Application number: 2024/90817	
What is the application for?:	Change of use of existing garden building to create mixed use hair salon to faci
Address of the site or building:	388, Bradley Road, Bradley, Huddersfield, HD2 1PU
Postcode:	HD2 1PU

Type of comment: An objection	
Do you wish your comments to be published on the website anonymously?	Yes
<p>FOR THE ATTENTION OF KATIE CHEW</p> <p>I OBJECT TO PLANNING APPLICATION NUMBER: 2024/62/90817/W - 388 BRADLEY ROAD HUDDERSFIELD HD2 1PU</p> <p>I OBJECT TO THE PLAN FOR A MIXED USE HAIR SALON TO WORK FROM HOME IN A BACK GARDEN - I OBJECT TO A COMMUNAL ROOM AND RESIDENTIAL ANNEX WITH FORMATION OF GUEST SPARE BEDROOM AND GUEST PARKING SPACES.</p> <p>THIS WOULD BE SO OUT OF CHARACTER IN A RESIDENTIAL AREA - BRADLEY ROAD.</p> <p>ESTABLISHED HAIRDRESSERS ONE MILE AWAY ALREADY EXISTS ON BRADLEY ROAD.</p> <p>IF HUDDERSFIELD HAS NO AVAILABLE UNITS, BRIGHOUSE HAS WITH OFF STREET PARKING AND WOULD BE MORE APPROPRIATE LOCATION FOR A HAIRDRESSING BUSINESS.</p> <p>ALSO OBVIOUSLY ACROSS BRADLEY ROAD A SUITABLE LOCATION EXISTS AT THE BUSINESS PARK!</p> <p>I OBJECT TO THE NOISE AND DISRUPTION TO ADJOINING NEIGHBOURS BY PROPOSED CUSTOMERS AND DELIVERIES

Proposed Site Plan 1.500

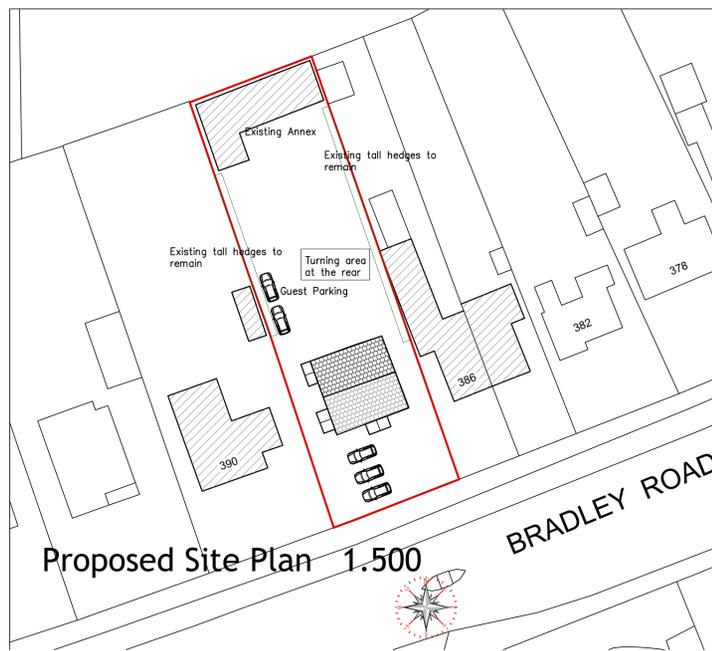
IF THE LATEST SITE PLAN HAD SHOWN THE NEW PREVIOUSLY
APPROVED HOUSE WITH LARGE WRAP AROUND EXTENSION PROTRUDING 4
METRES TO REAR (2023/62/92759/W IT SHOWS
HOW DIFFICULT OR IMPOSSIBLE IT WOULD BE FOR ANY PROPOSED
CUSTOMERS TO PARK AND TURN AROUND TO EXIT FROM PROPOSED
HAIRDRESSING BUSINESS.

CAR PARKING FOR OVER 20 CARS - WAS STATED BY APPLICANT ON
PREVIOUS PLAN (2023/62/92759/W AND SO A NEW TURNING AREA IS HIGHLY
UNLIKELY.
